**Proposed Amendment to Approved Layout for Residential Development -
H03/1450/00**

Application no: H03/1450/00

Description: Erection of 3 detached
dwellings

Location: Land at Counter Drain Drove
(Between Rose Villa & Beehive Cottage)
Tongue End
Spalding

HOUSE TYPE "B"

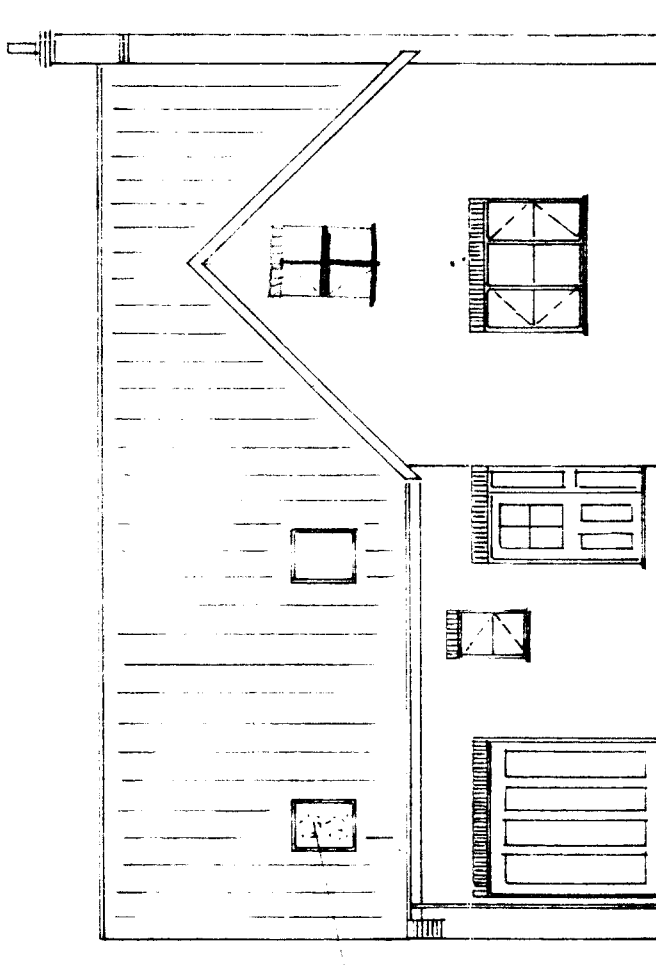
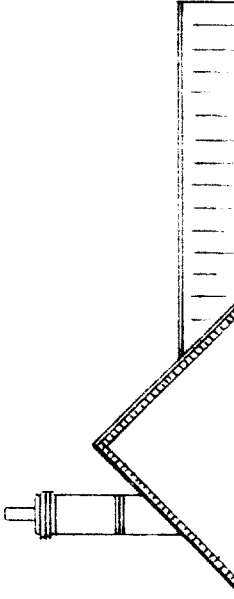
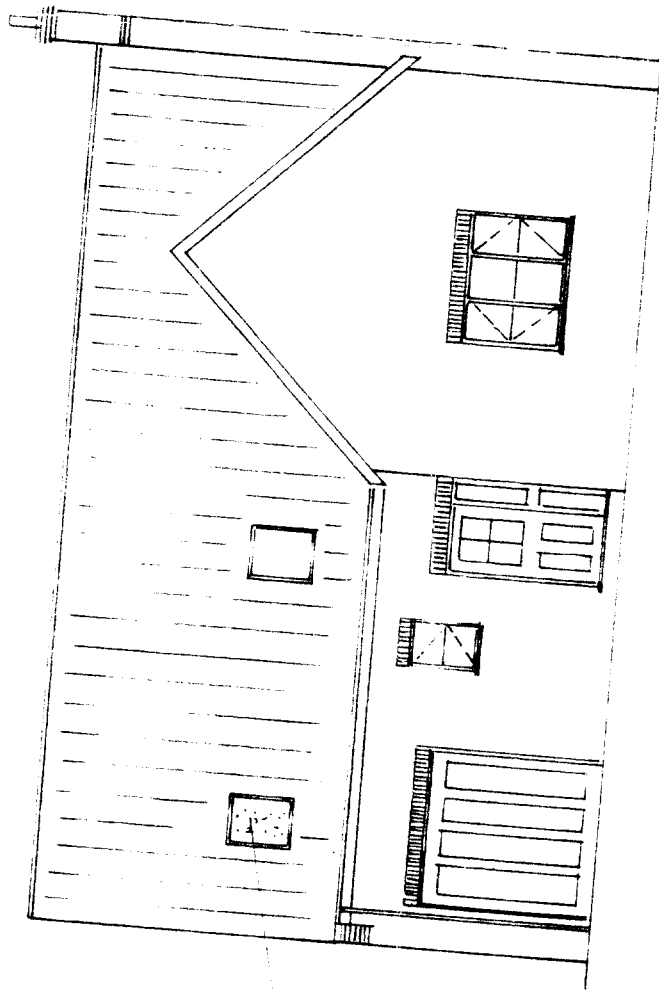
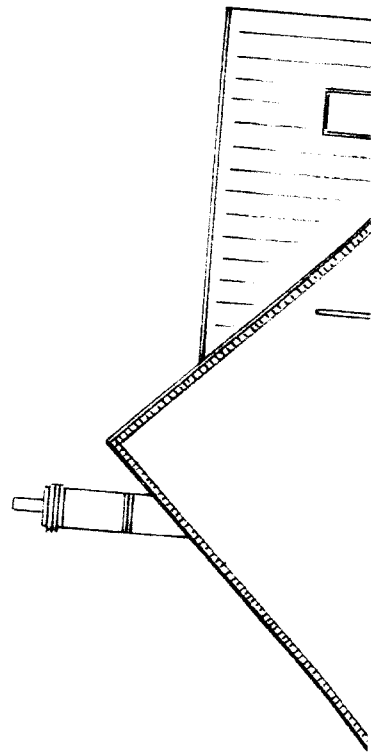
Plot 2, house type 'B' is currently under construction and has reached 'wall plate' level. We feel that this house type requires an additional window to its front elevation to bedroom four and removal of its roof lights.

There is currently no window, apart from the Velux roof style, overlooking the front of the property and the proposed roof lights to the side elevations of bed four will be overlooked by both plots 1 and 2.

We have attached an 'existing' and 'revised' sketch of our proposal.

Amendment: Alterations to Plot 2
LG Construction Service letter of 21Apr 2002 & elevations

The amended details submitted in respect of the above proposal have now been considered and there are no objections to the amendment being implemented to the extent described above.

PROPOSED LAYOUT SCALE 1:200

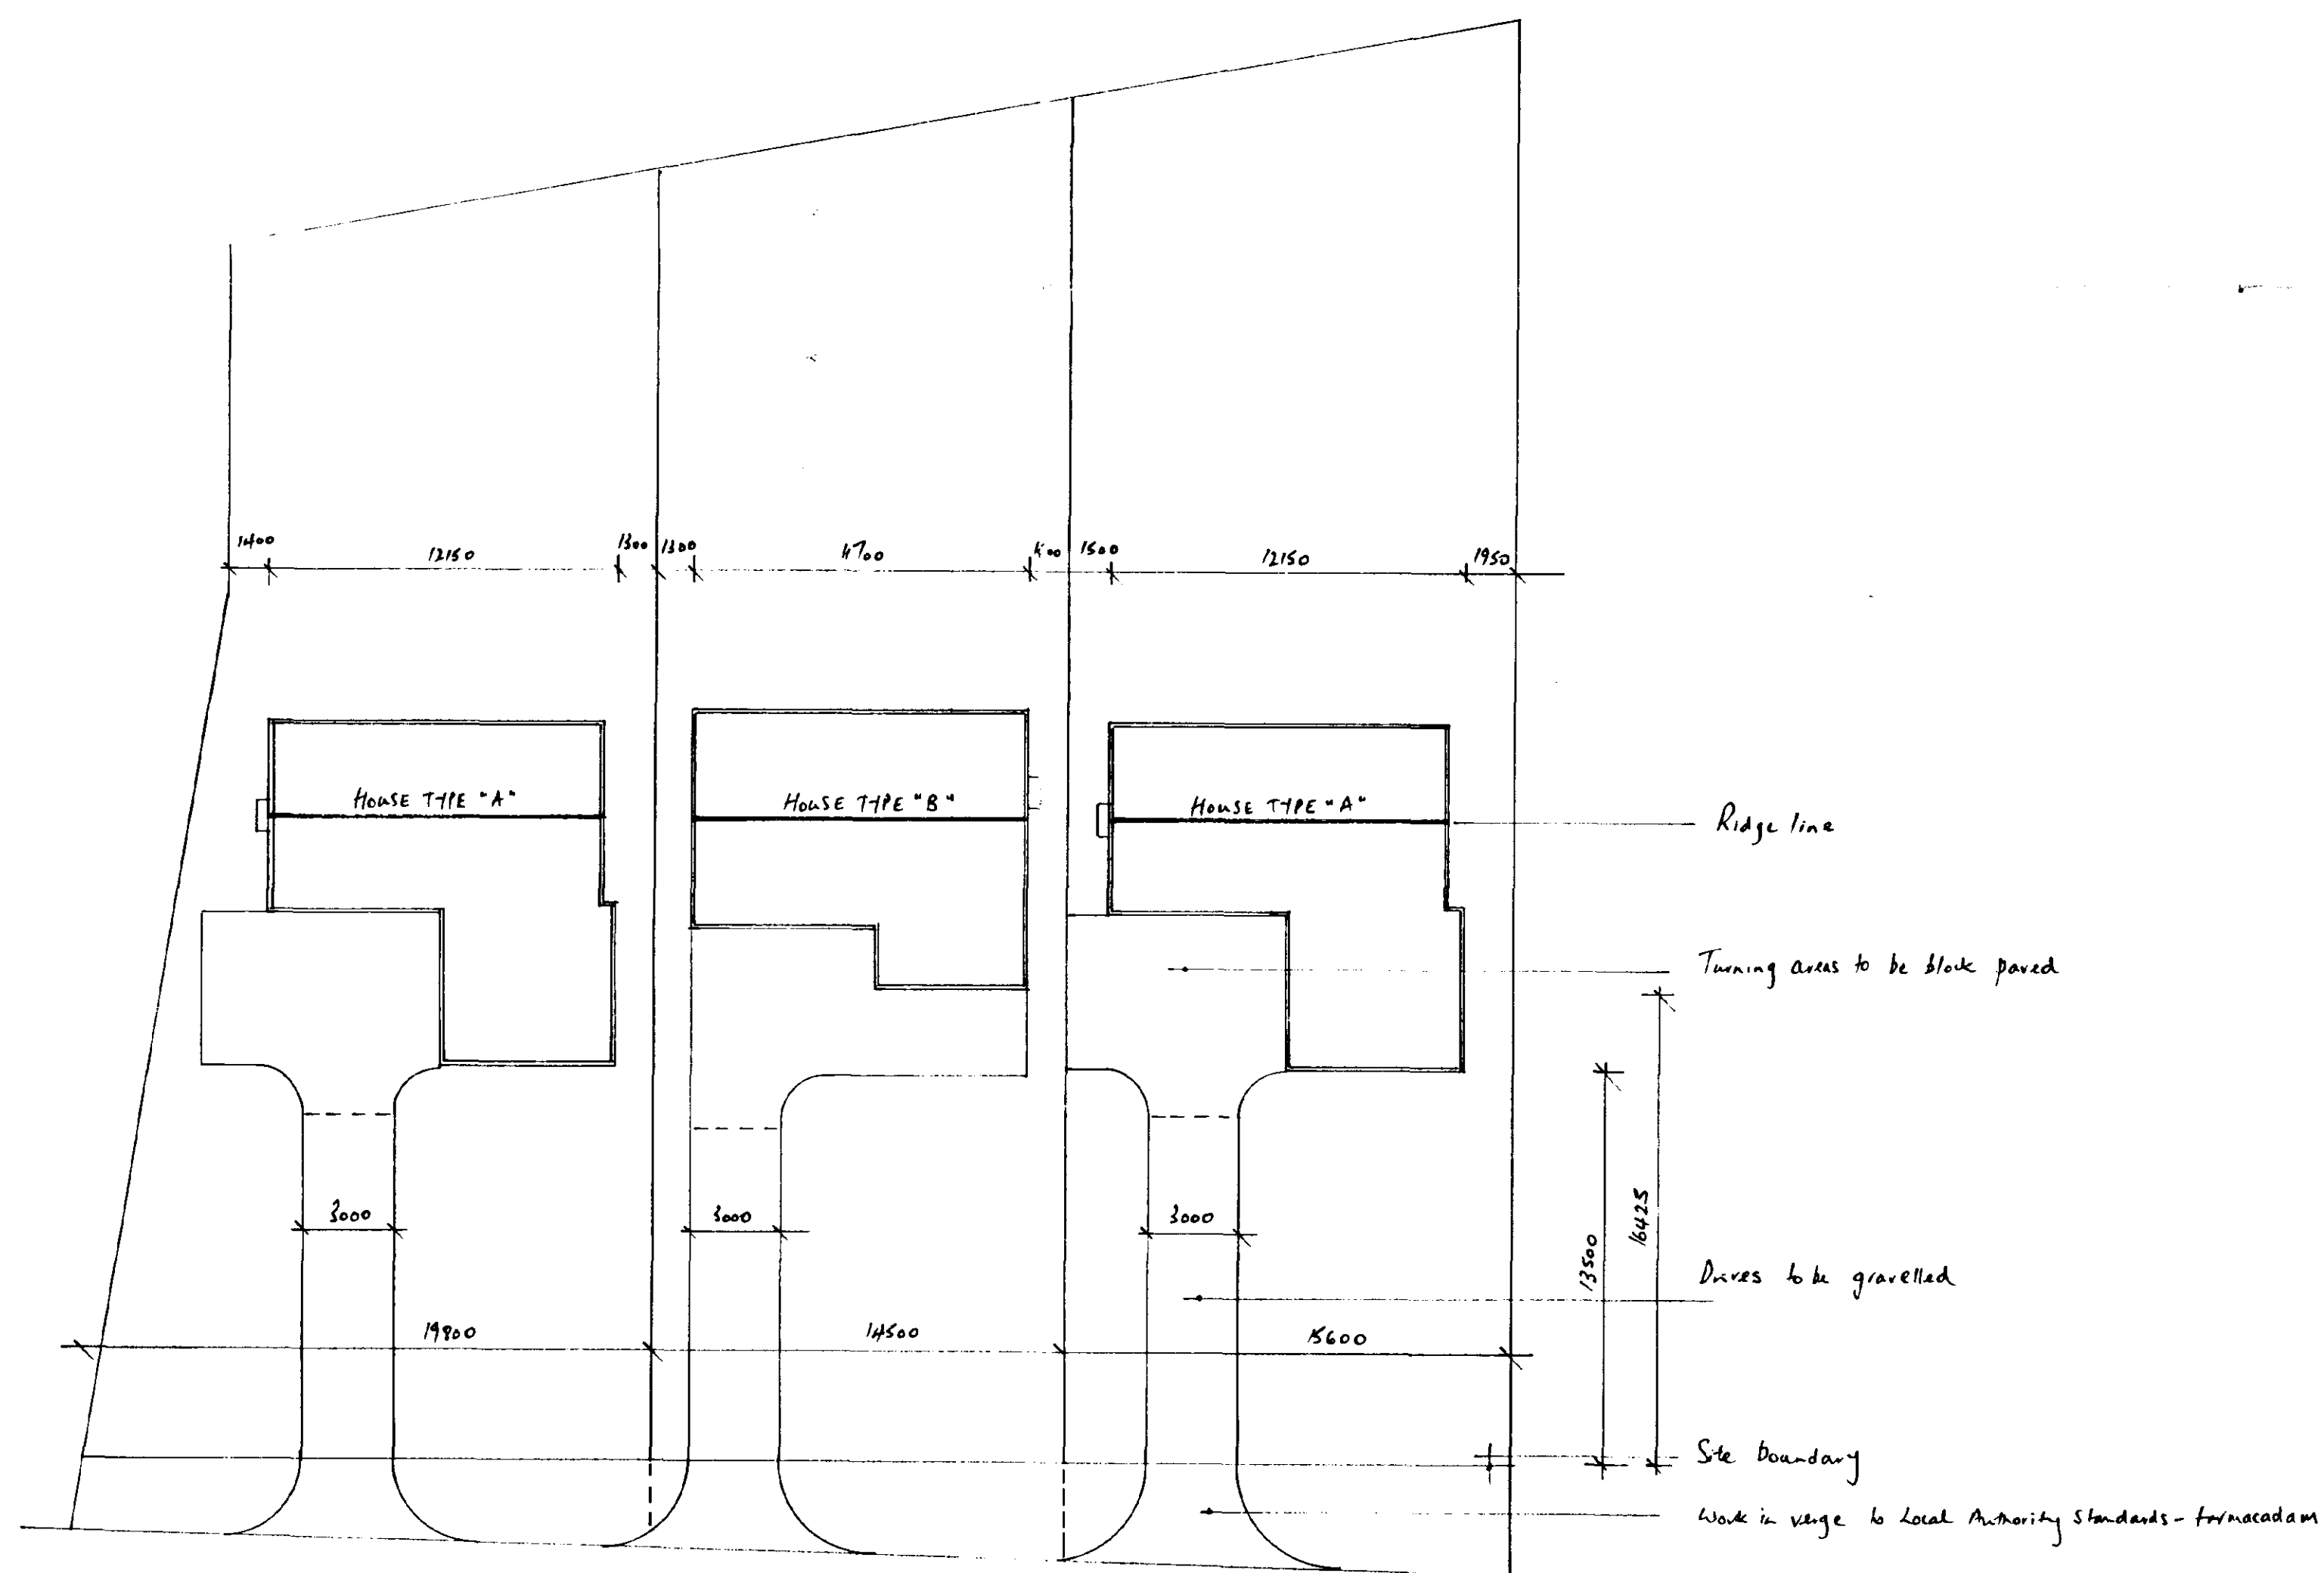
I note the only amendment is the movement of house type "A" 1 metre on Plot 3 to the north east. Plots 1 and 2 remain the same.

The impact of this change is to close the gap between the houses from 3 metres to 2 metres.

I consider that the change is not significant and can be accepted as a minor amendment to the existing approval reference H03/1450/00.

The amended plans have been stamped and added to the approved plans on the file.
